**RE: Frito Lay Parking Expansion
1550 Mission Drive NE
Grading and Drainage Plan
Engineer's Stamp Date: 4/13/18
Drainage File: F16D051**

Based on the information provided in your submittal received 4/16/18, the grading and drainage plan is approved for Grading and Paving Permit.

RE: **Frito Lay Parking Expansion**
1550 Mission Drive NE
Grading and Drainage Plan
Engineer's Stamp Date: 3/30/18
Drainage File: F16D051

ENGINEER'S SEAL  3/30/18 DAVID SOULE P.E. #14522	1550 MISSION AVENUE FRITO LAY GRADING AND DRAINAGE PLAN  1606 CENTRAL AVENUE SE SUITE 201 ALBUQUERQUE, NM 87106 (505) 872-0999	DRAWN BY WCVJ DATE 3-29-18 21880-LAYOUT-3-29-18
		SHEET # JOB # 21880

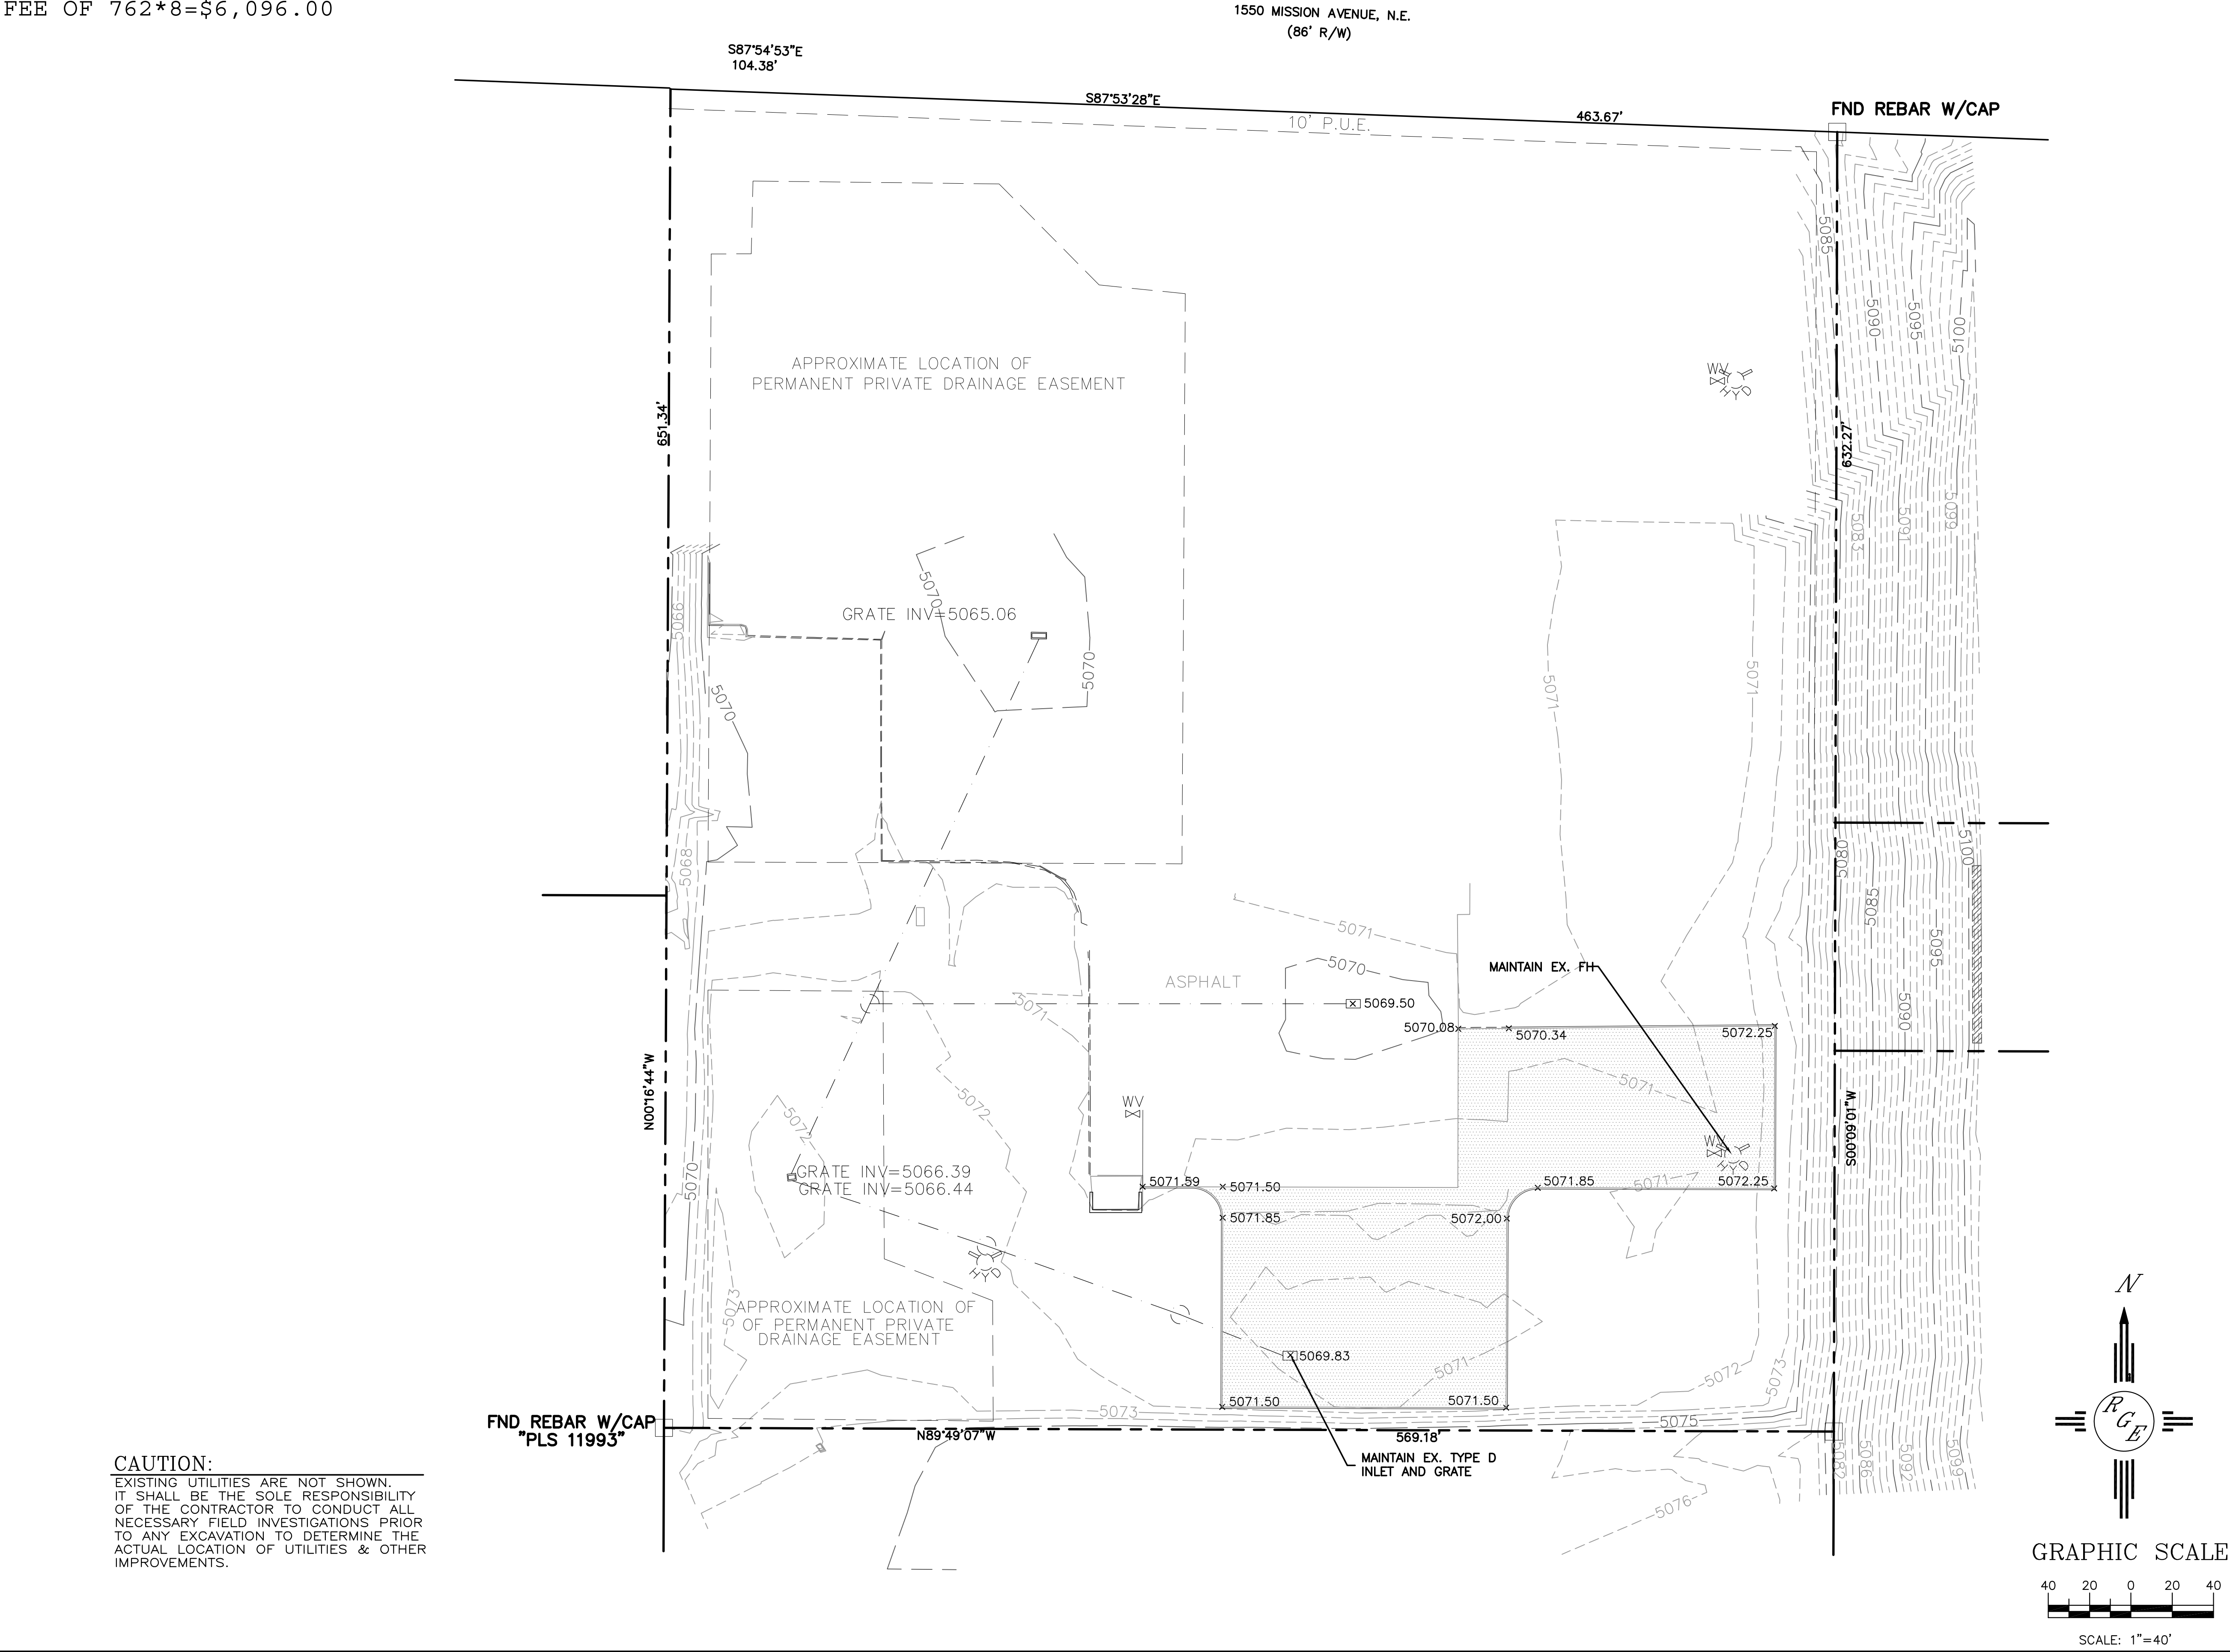
1. Show and state the areas of grading and new paving. Include proposed contours and proposed grading around the new parking lot. **WE HAVE ADDED AREAS AND CONTOURS**
2. Provide drainage calculations to support the first flush bypass volume. **WE HAVE ADDED CALCULATIONS**
3. Payment of Fee-in-Lieu will be required if not ponding on-site. Once the calculations are provided and verified, a treasury deposit slip will be generated for the bypass volume. **ACKNOWLEDGE THE FEE WILL BE REQUIRED**
